From: Tom Ford [REDACTED]
Sent: 14 July 2022 12:18
To: Maria Tomalova <Maria.Tomalova@arun.gov.uk>
Cc: Edward Barron [REDACTED]
Subject: RE: P/82/22/PL

Subject: P/82/22/PL

Drawing **PROPOSED SITE/BLOCK PLAN**

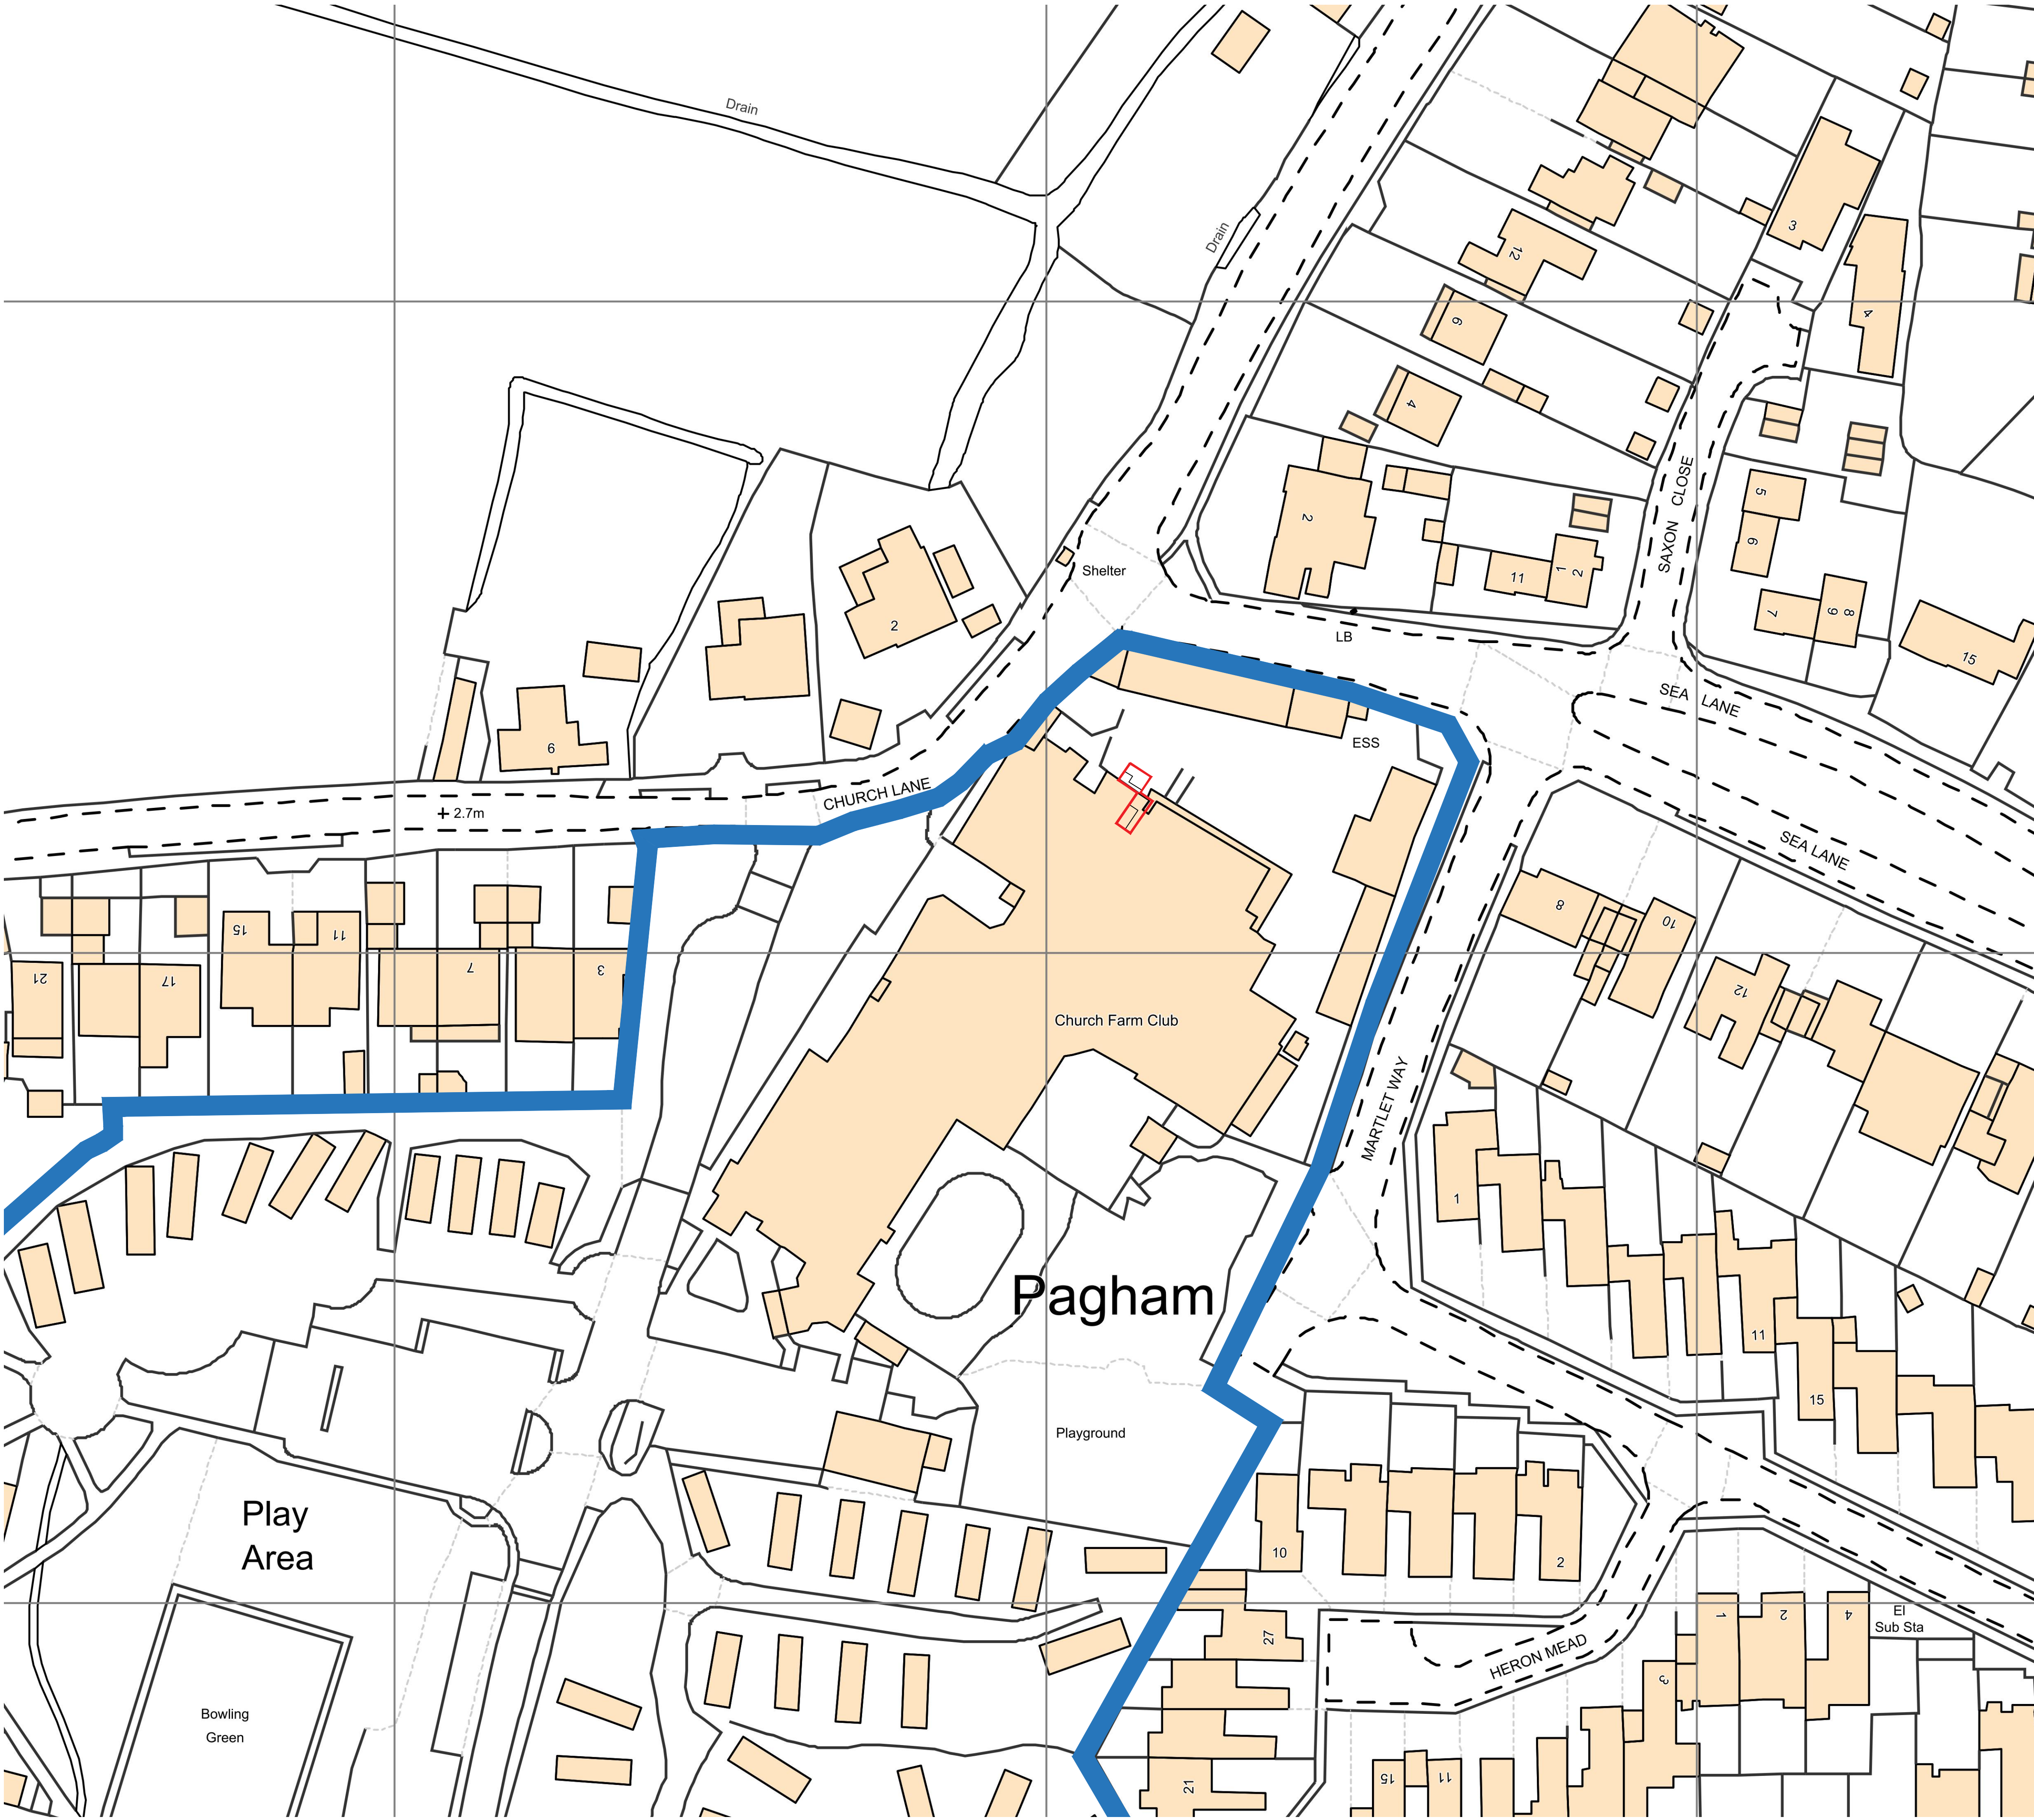
Apologies, I have re-read my original email in relation to this and realised that I have not been clear. Please could the applicant provide a BS 4142 assessment to answer the queries from my last email?

Please could the applicant confirm whether noise from the unit has been taken into account when siting this unit? Whilst I note that the acoustic data has been provided in the manufacturers specifications, I am unsure which way round the unit will be faced, and whether the residential dwellings over the road have been taken into account when siting the unit?
